MECKLENBURG COUNTY
Park and Recreation Department

MEMORANDUM

DATE: November 27, 2023

RE: Rezoning Petition #2023-038
PID# 18722133

SCHMATIC SITE PLAN

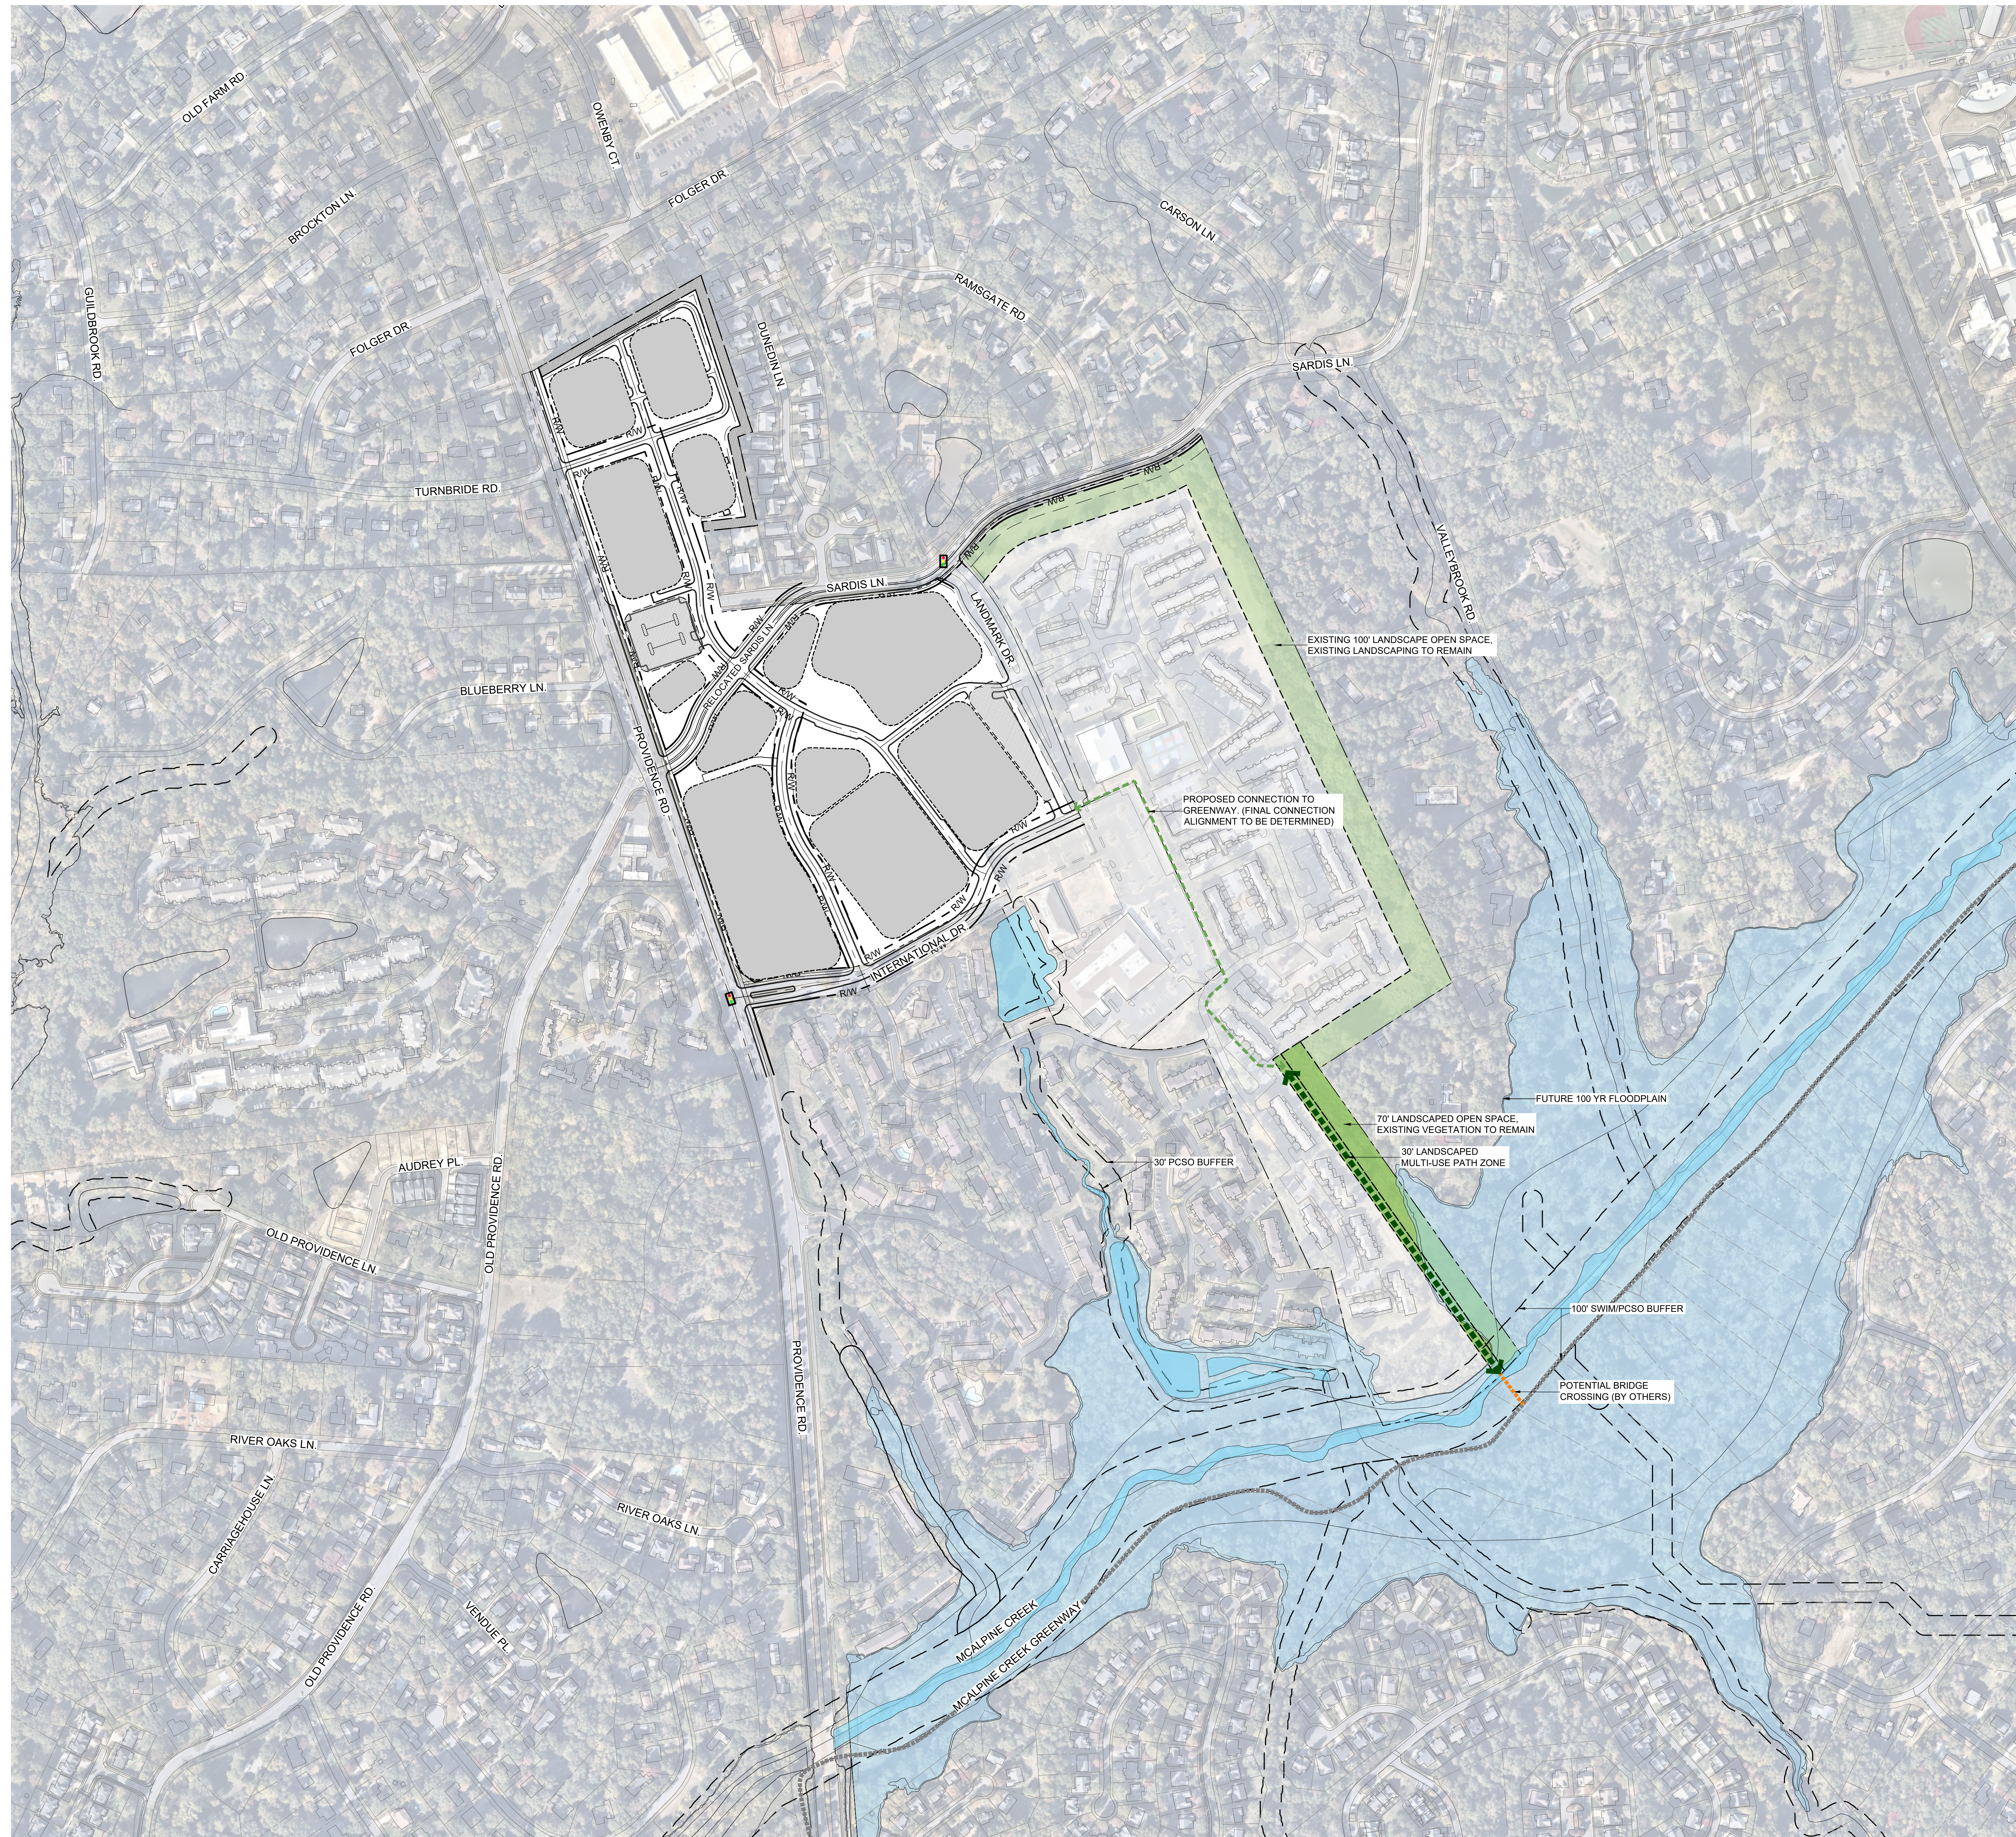
MCPR requests minimum of 4.2 acres to be dedicated and conveyed to Mecklenburg County for a future local park. This requested park land shall be adjacent to a public right-of-way for access and is conducive for the development of the typical amenities found in a local park and cannot include tree save parcels or stormwater BMP's.

Additionally, MCPR requests a bike/pedestrian connection to the existing McAlpine Creek Greenway trail and the dedication and conveyance of the 100' SWIM along McAlpine Creek to Mecklenburg County as permanent greenway easement. Greenway easements may overlap tree-save. Greenway easements and parkland dedication shall be conveyed by the first CO.

Based on the revised site plan we have the following comment: MCPR Planning Staff have met with petitioner and are discussing opportunities to meet the above request.
